**Consultation Response from Trees Planning,
 KC Trees**
2019/90634 adj, Netherfield House, 12, Riley Lane, Kirkburton, Huddersfield, HD8 0RY
Erection of detached dwelling with associated landscaping, incorporating existing garage and private driveway
Date Responded:
Responding Officer:
Responding Ref: 07/89

Drawing:
Tree Constraints Plan

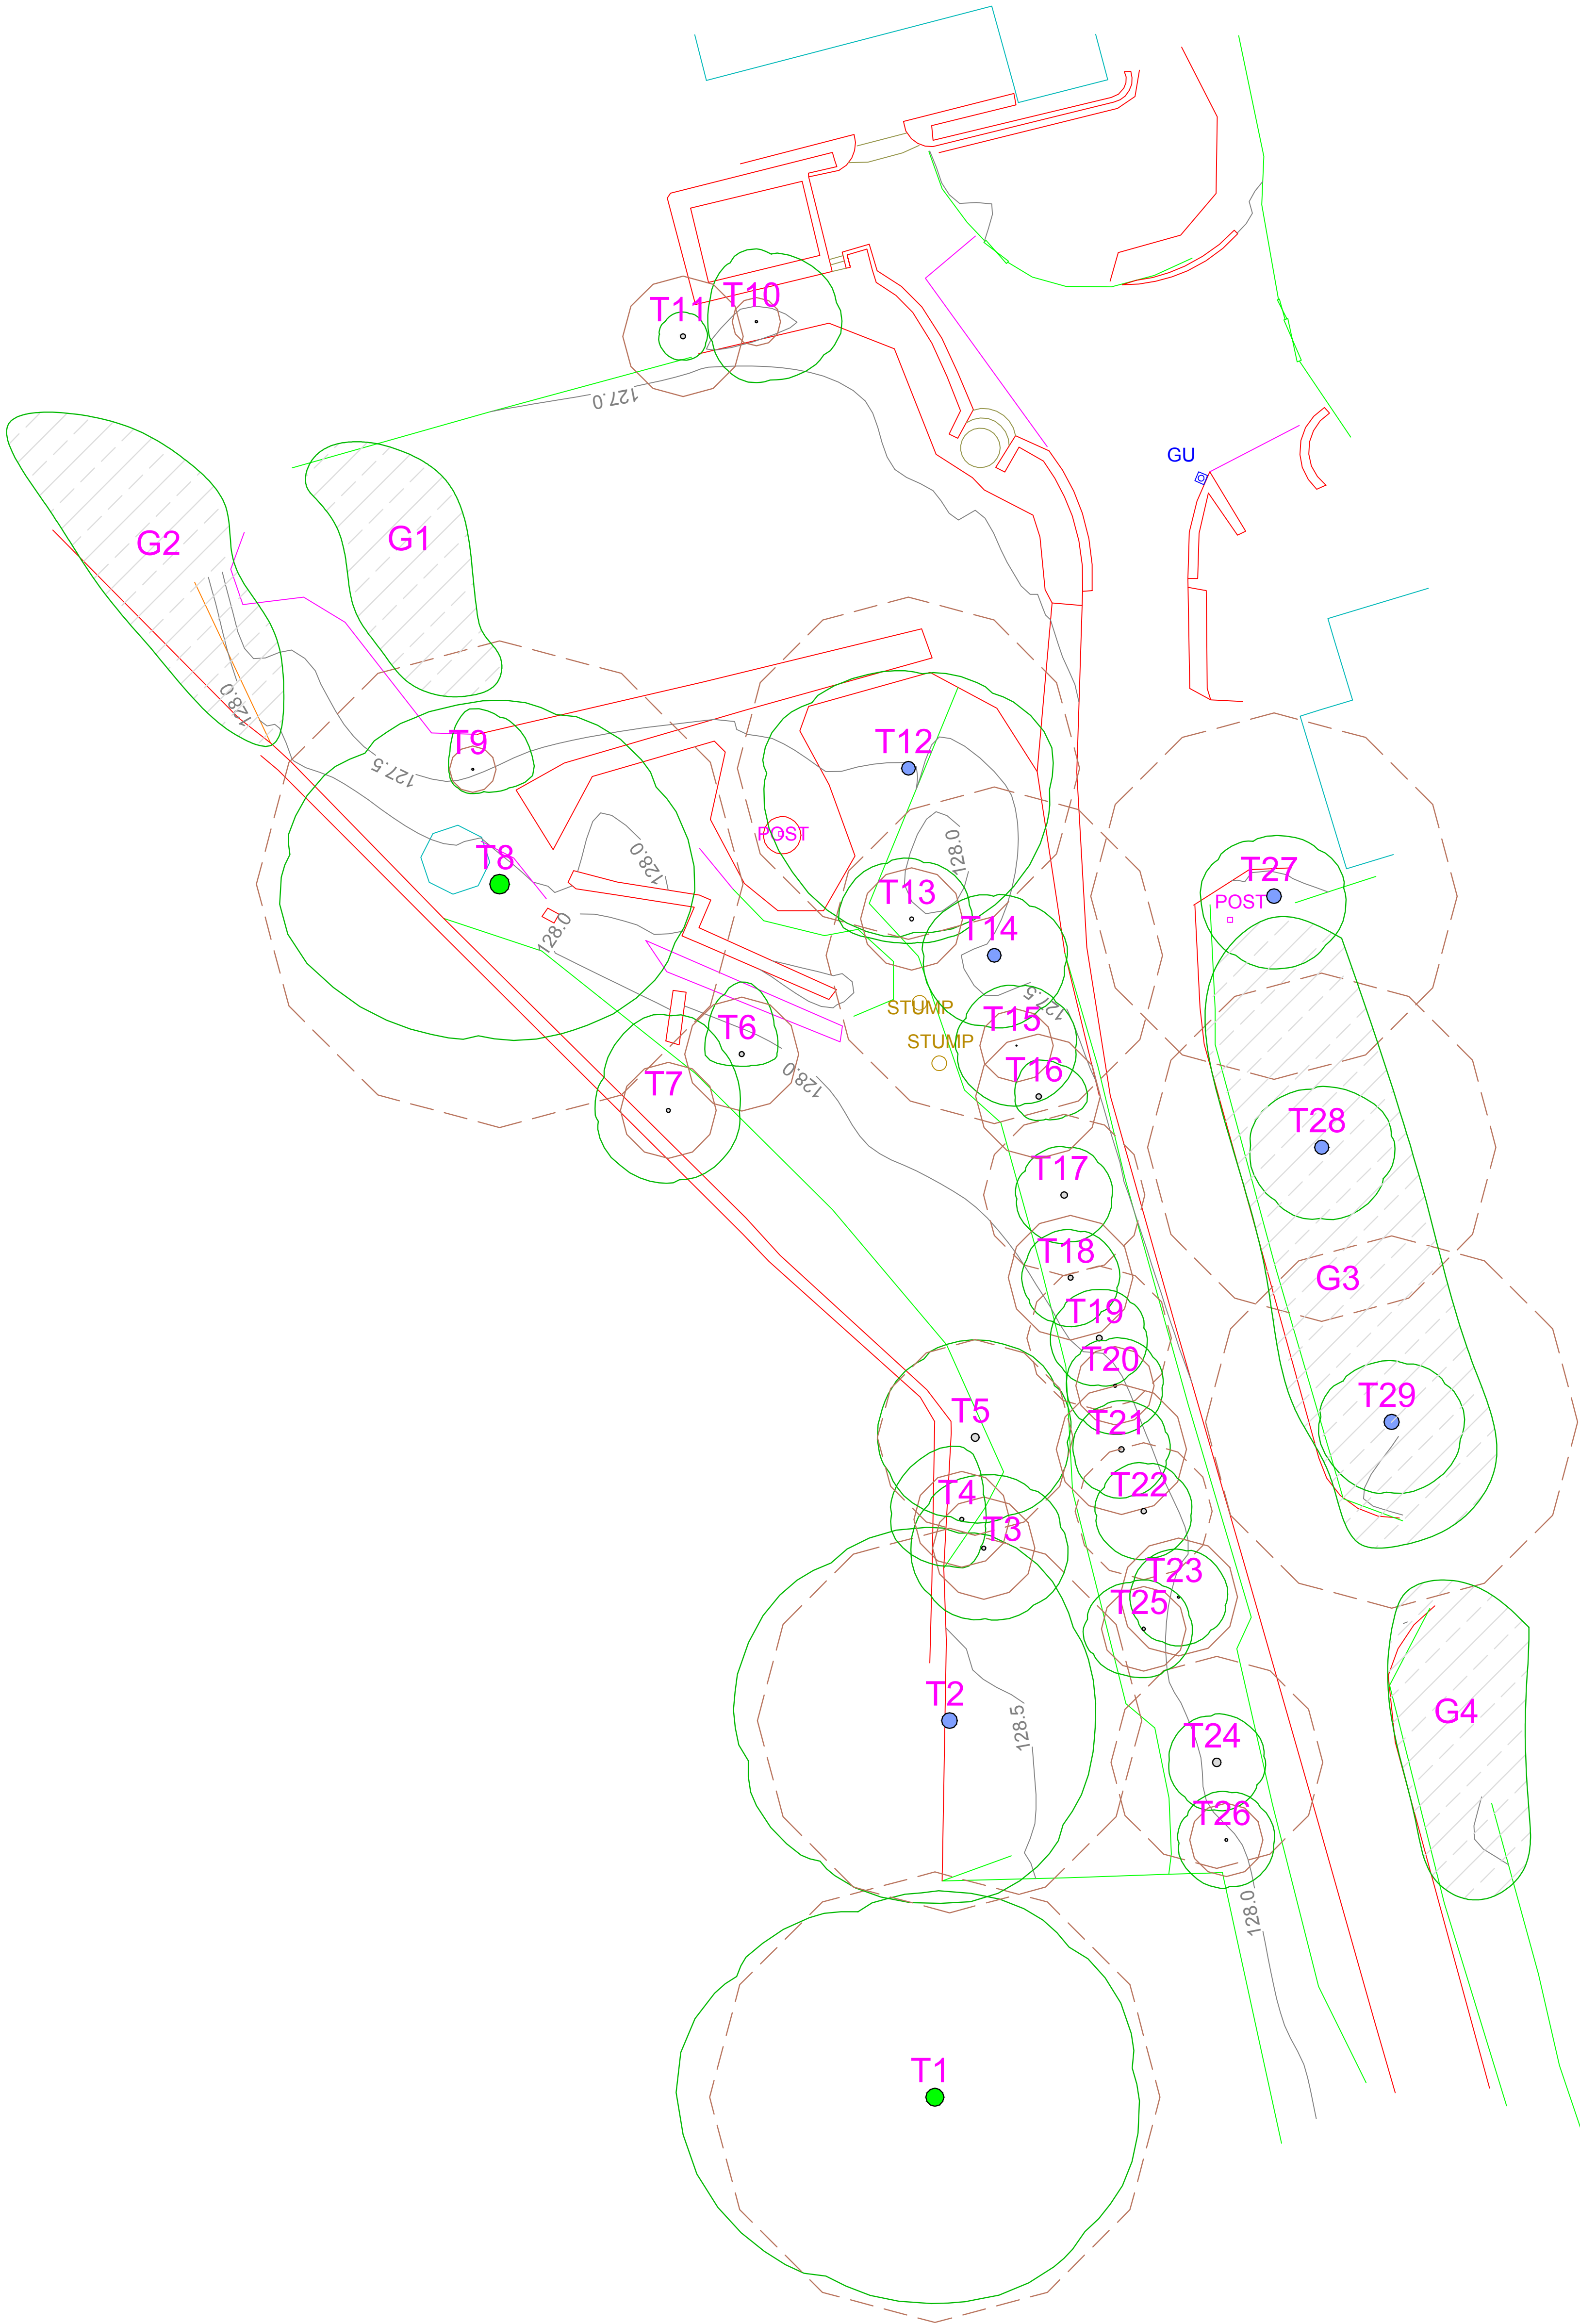
The Oak, numbered T8, however should be retained and incorporated in the design of the proposals. The site is constrained by its sheer geography however this is exacerbated by the size of the proposed dwelling which has left no space within the site to allow this tree's retention. The TPOs on this site protected numerous trees along the boundary which T8 sits on, most of which have been removed for one reason or another over the years and so this is one of the last mature trees that provide amenity value on this boundary. I am not satisfied that there is sufficient justification for the loss of this tree especially given the scale of the proposed building which if smaller could accommodate the retention of T8.

Proposed Landscape Plan

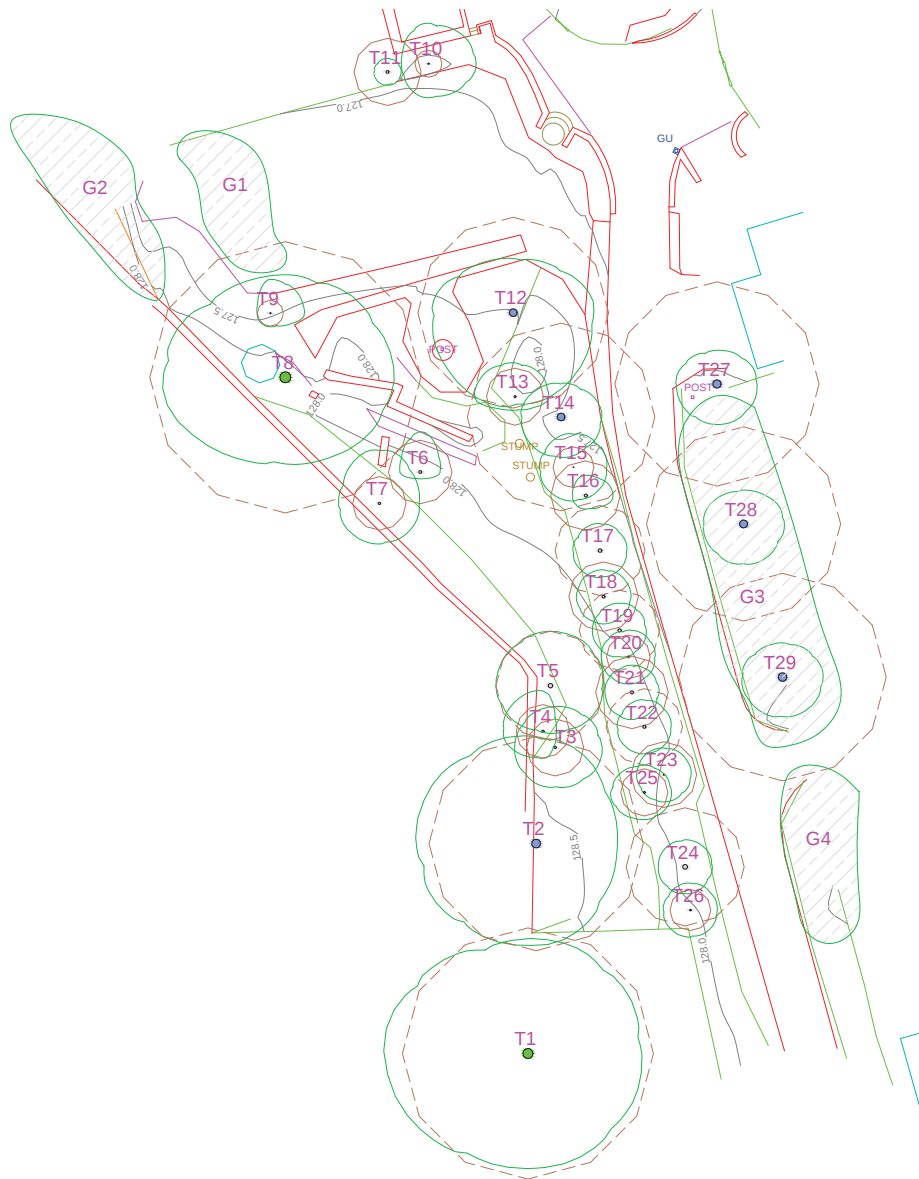
The loss of the protected trees, previously approved, would alter the entrance drive to Netherfield House and views towards Netherfield House and its grounds from further up Riley Lane. The replacement planting required should be shown on the submitted drawings to demonstrate it can be achieved with these proposals and the planting should seek to provide ornamental replacements of the smaller trees and sufficient mitigation on the site's boundary with the field for the larger trees.
